From: Thomas Callaway
Sent: 29 September 2016 13:12
To: Planning.Responses
Subject: RE: Planning Consultation on: BN/43/16/PL

BN/43/16/PL

Angels Nursery Yapton Road Barnham PO22 0AY

95 No. dwellings together with access, landscaping open
space & associated works.

TITLE: Block Plan

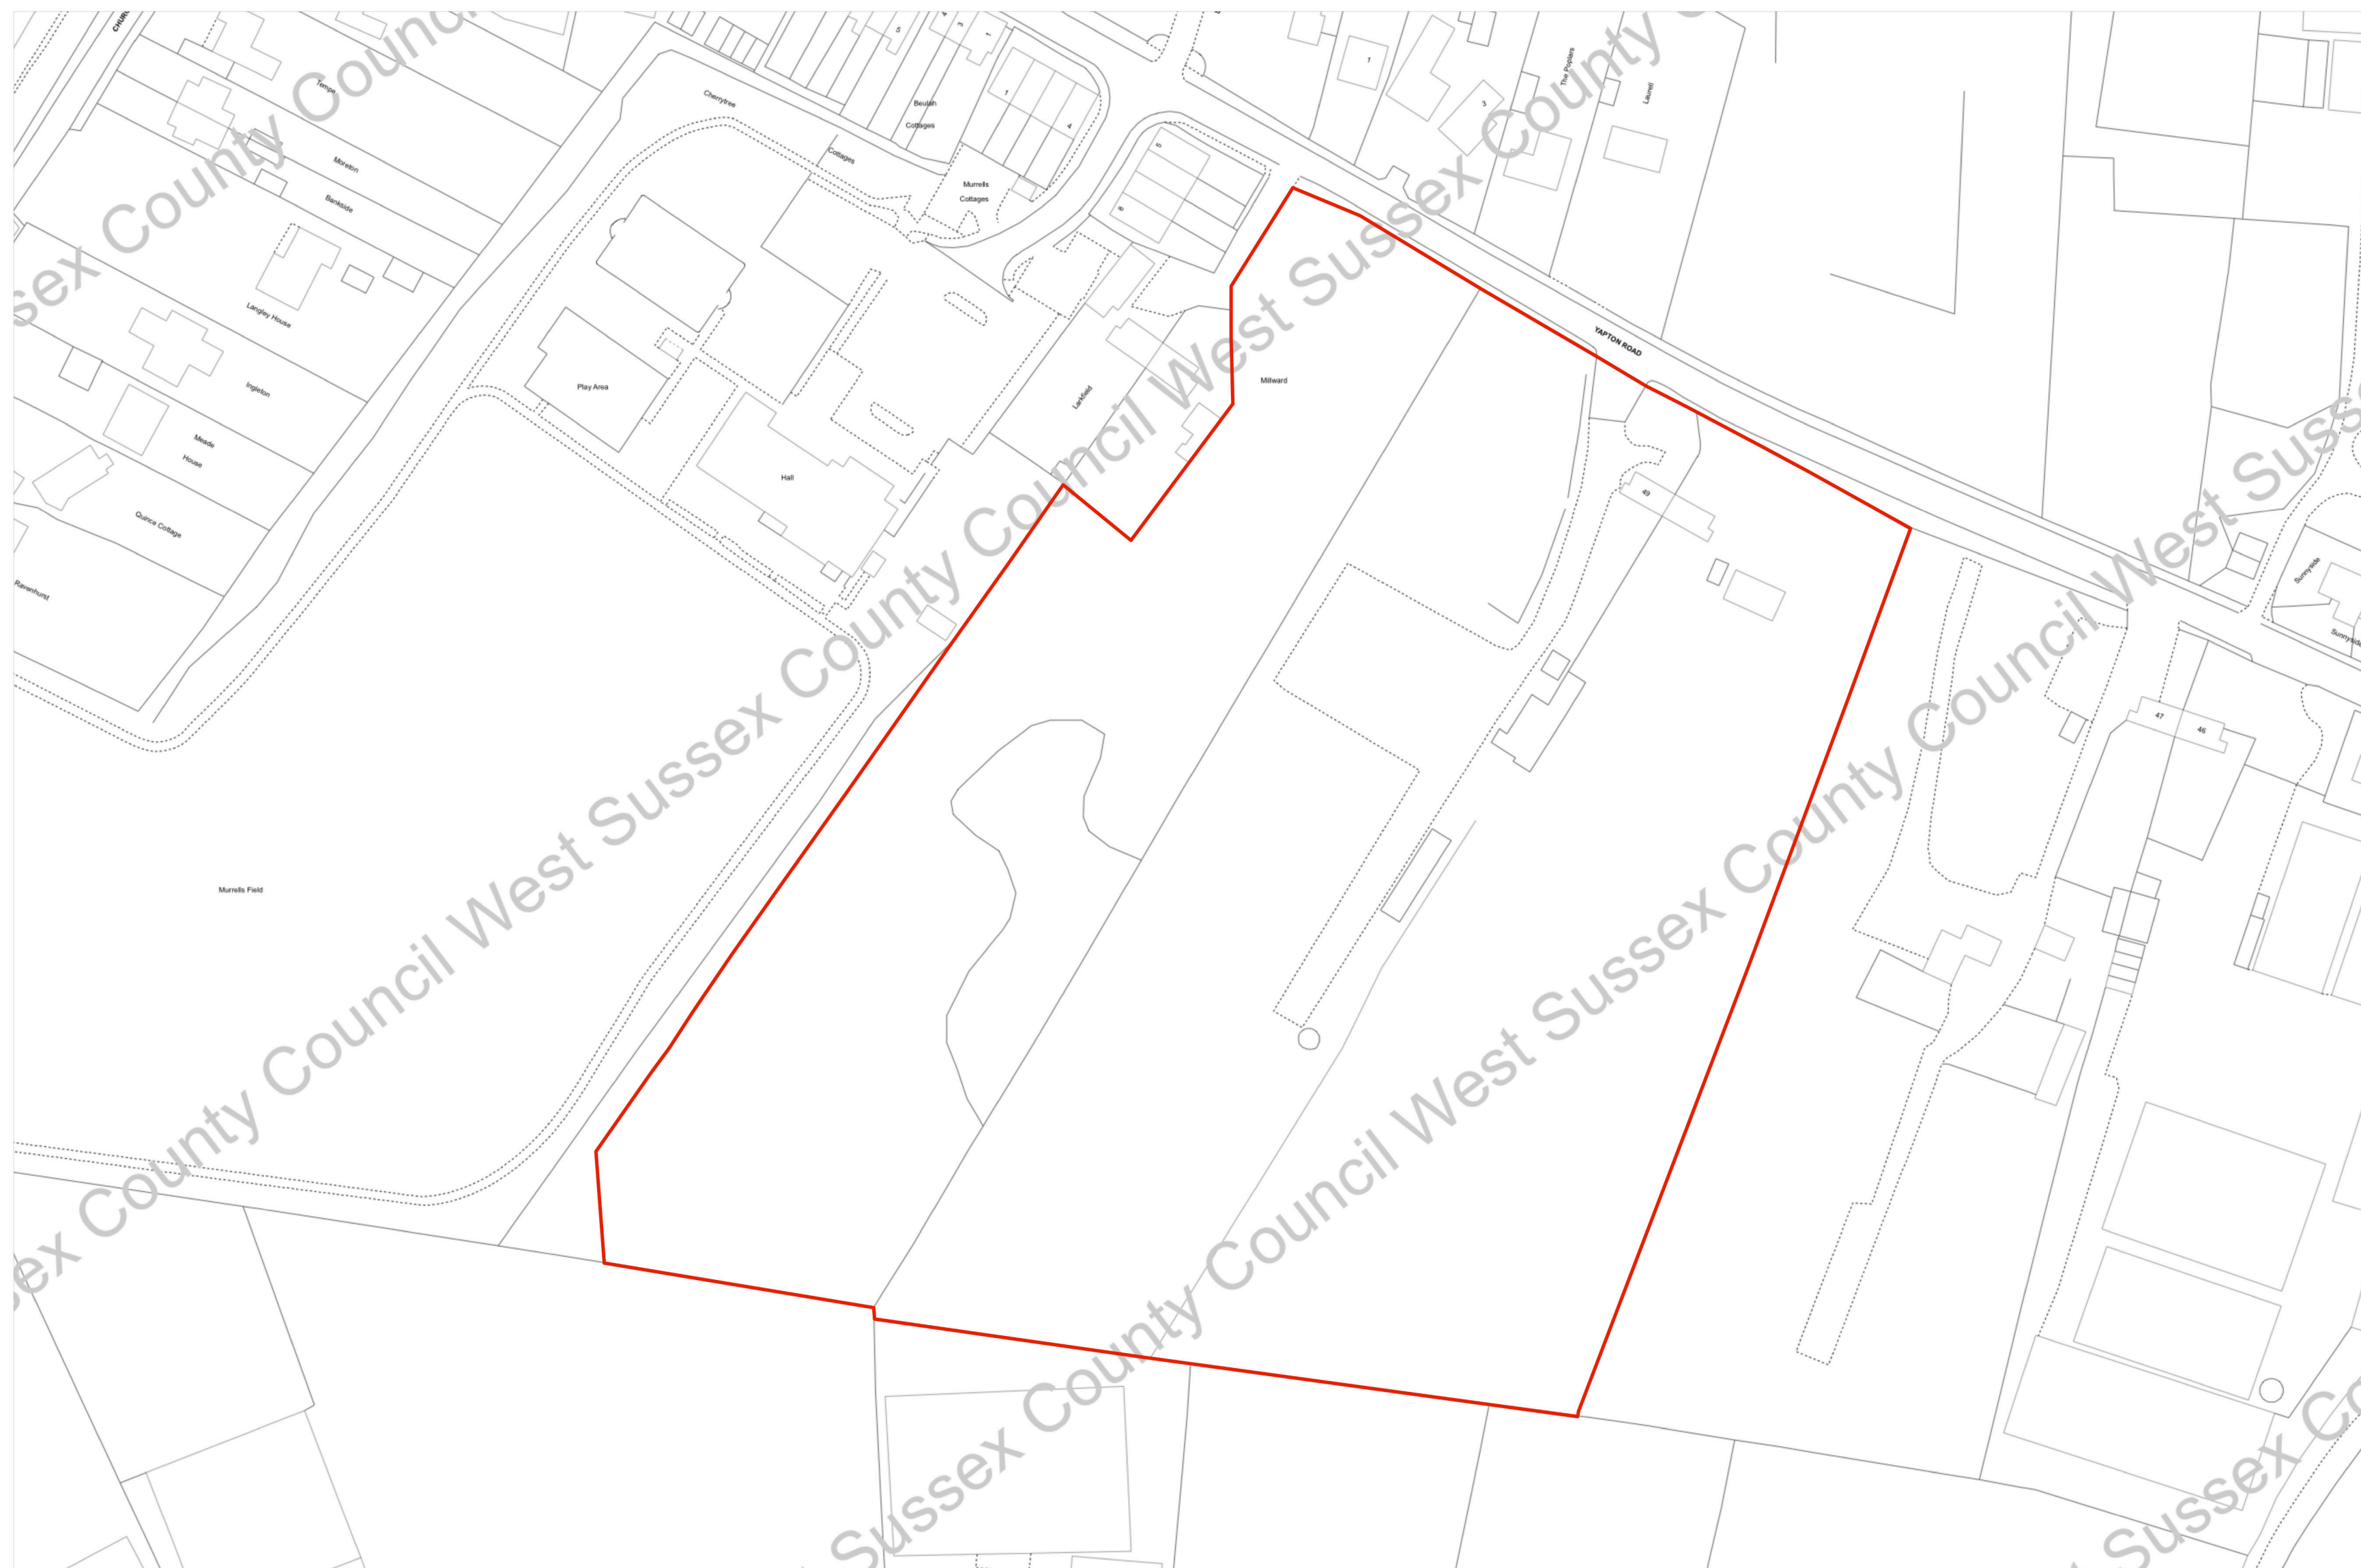
The surface water drainage design for the previous application at this site consisted of attenuation with a restricted discharge to the ditch system bounding the site. It also allowed for the internal ditches to be filled, while retaining all ditches on the boundary and giving an easement for access and maintenance.

It must be ensured that suitable space is retained in the layout for the required volume of stormwater storage. Discharge rates would have to be revised if the proportion of impermeable area has changed.

Please apply conditions ENGD2B without the monitoring and testing requirements (ground conditions established in previous applications, please refer to these to inform the drainage design), ENGD3A, ENGD4A, ENGD5a, ENGD5B, ENGD6A
